Regulatory and Assessment.  
Reference: PB2018/08781

6 September 2018

## **UNIVERSITY OF NEWCASTLE HONEYSUCKLE CITY CAMPUS CONCEPT PROPOSAL (SSD 9262)**

Figure 4.2 Section A

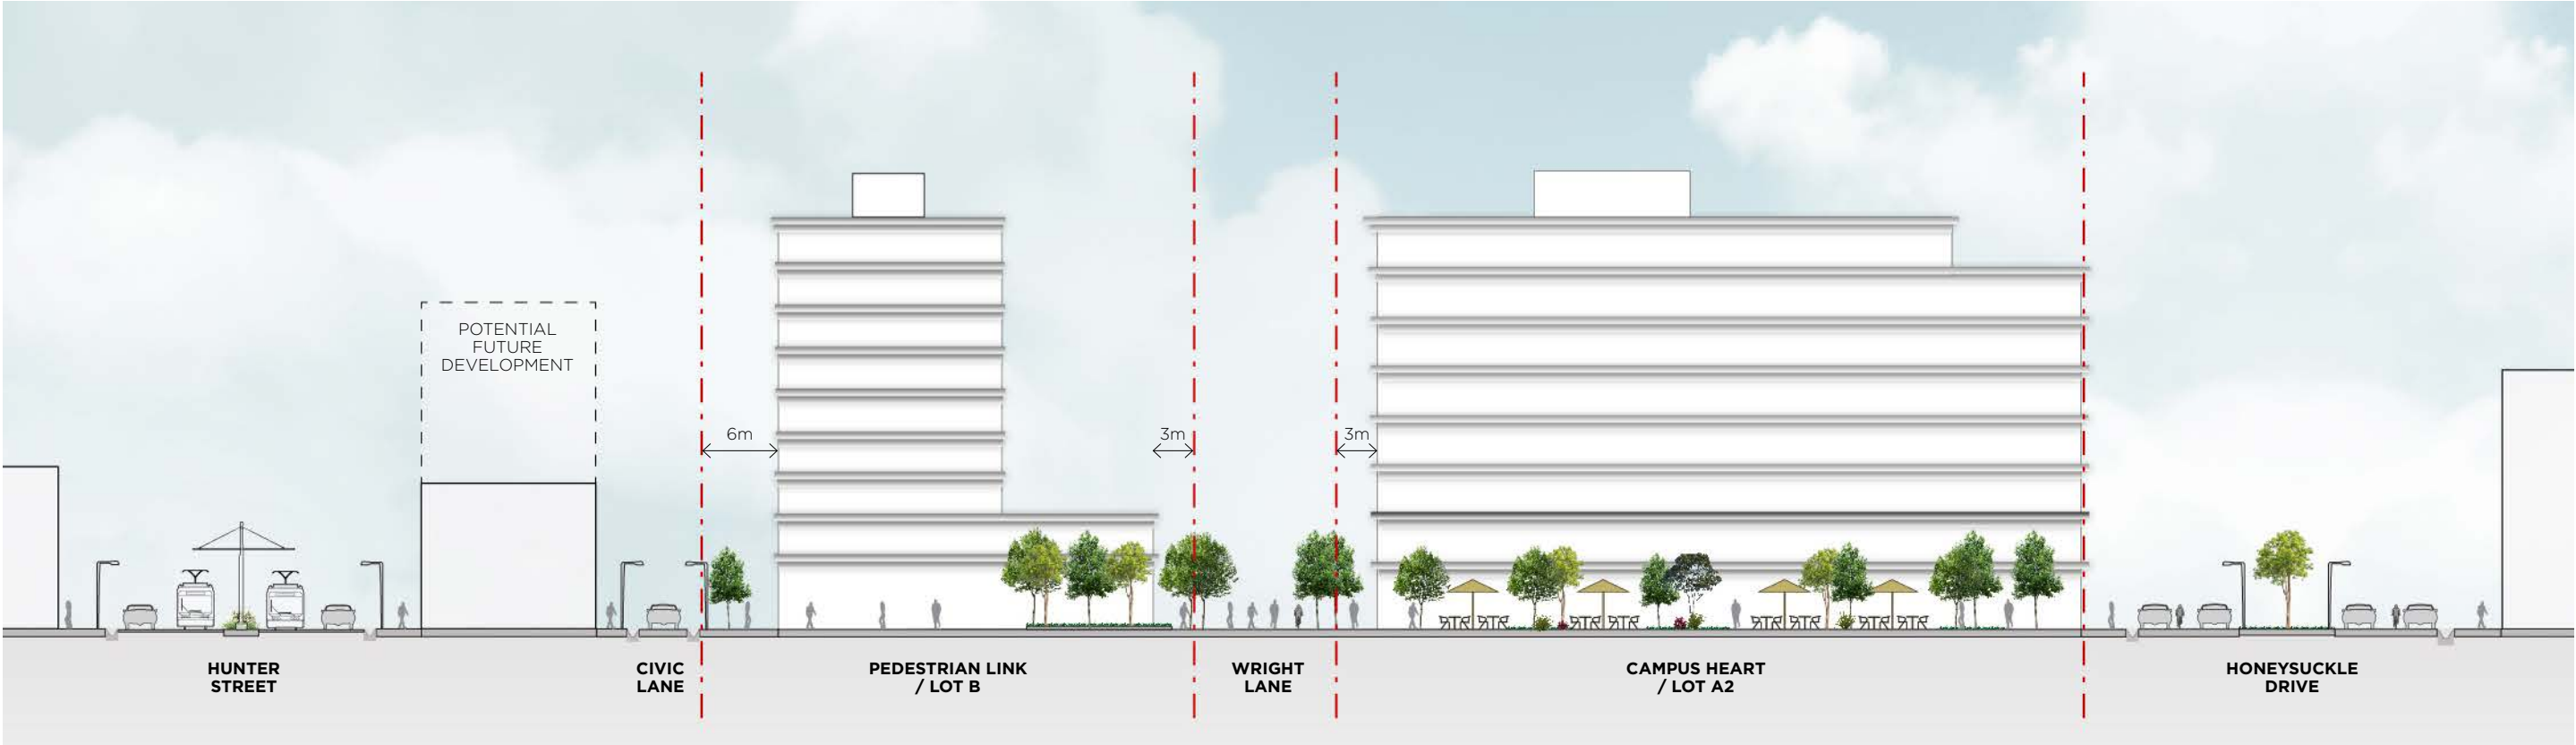
The Masterplan will result in a significant increase in intensity of land use for Civic Lane. Civic Lane is indicated to be used as one of the main pedestrian links through to an existing building on Hunter St. The laneway will need to be upgraded with provision of new widened footpath, new road pavement and street lighting.

Civic Lane may be appropriate for provision of loading areas, garbage pick-up, services access and new driveway accesses the site, provided that appropriate upgrading was undertaken to support the intensified use.

Figure 4.3 Section B

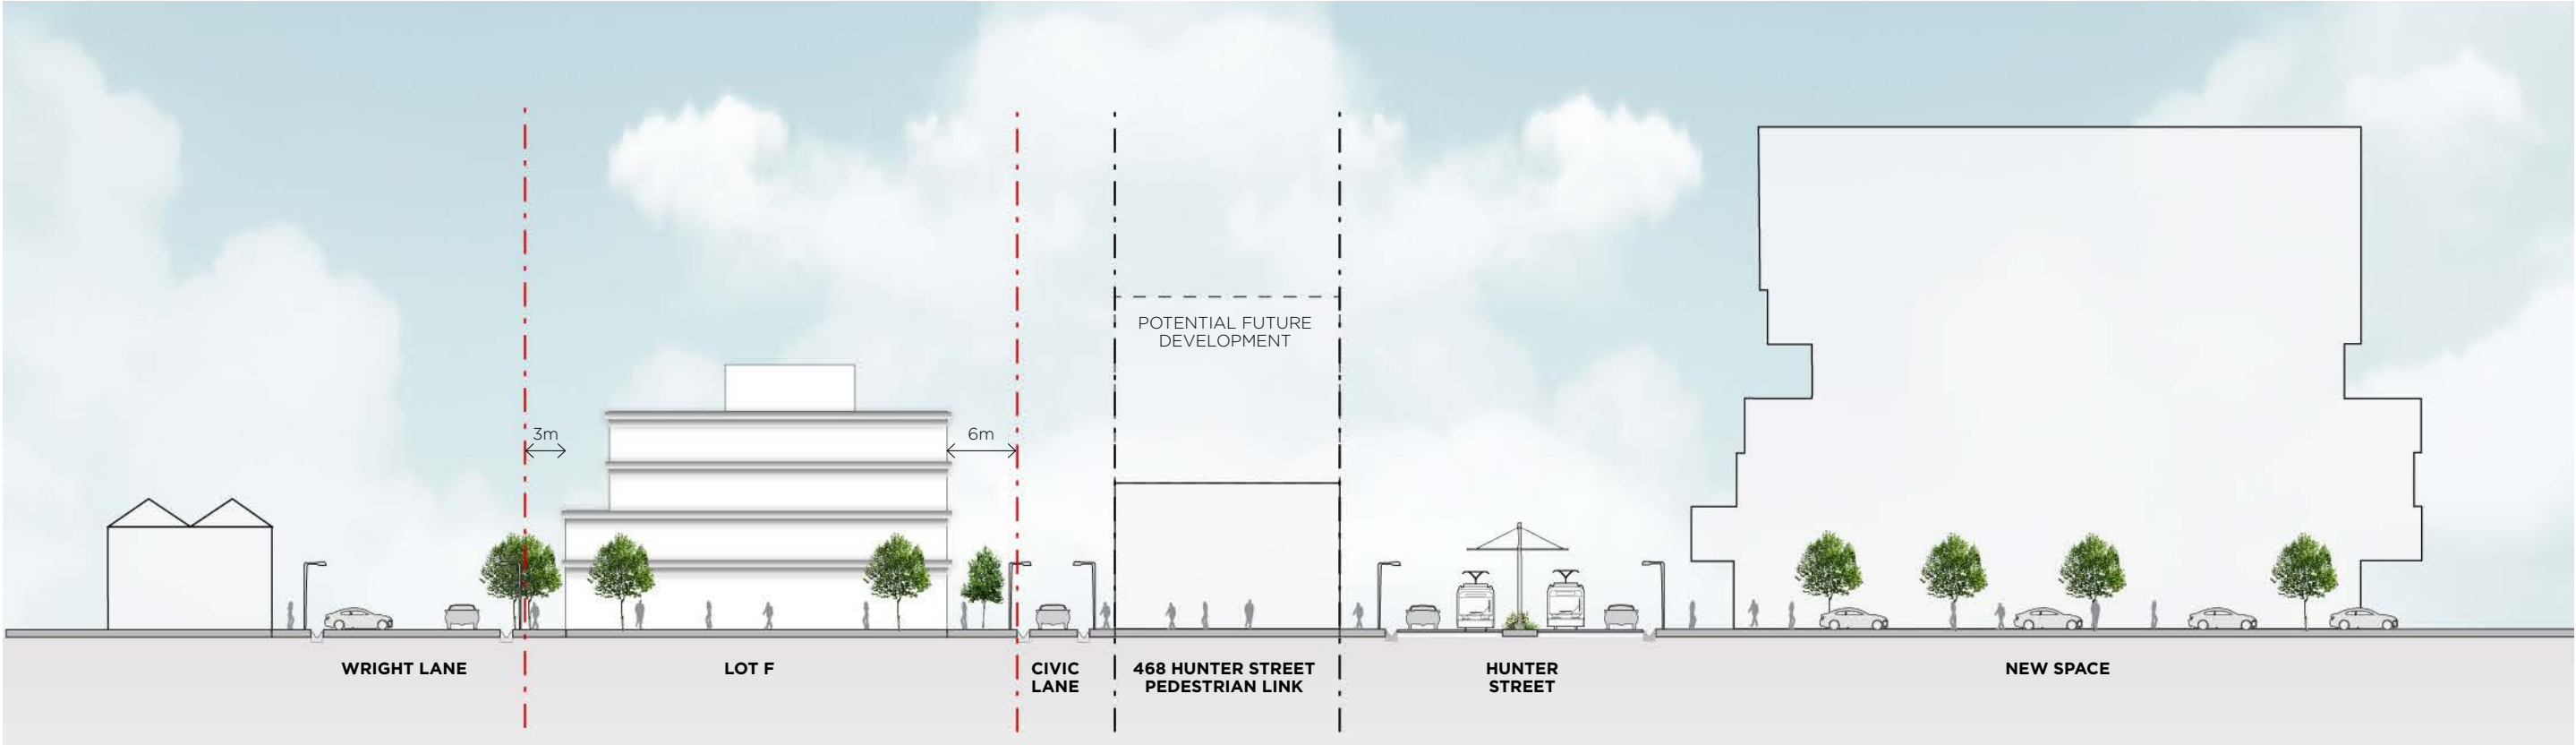
The EIS is silent on the future of the remaining Wright Lane, which is currently owned by Hunter Development Corporation. However, it is noted that Wright Lane may be dedicated to the City of Newcastle (CN) at some stage similar to Settlement Lane and Workshop Way which were dedicated to CN in March 2018. In this regard, it is recommended that the design of the Wright Lane be developed on the basis as a future public road in consultation with CN.

The floodway on Wright Lane adjacent to proposed Buildings B & D and Worth Place floodway is located at a critical part of the overall masterplan. The design of the floodway will be a major factor in determining the overall building design levels and design of the open space areas. Overland flow on Wright Lane fronting Buildings E & F, Settlement Lane, Civic Lane and the upper catchments of Wright Lane will need to be resolved.
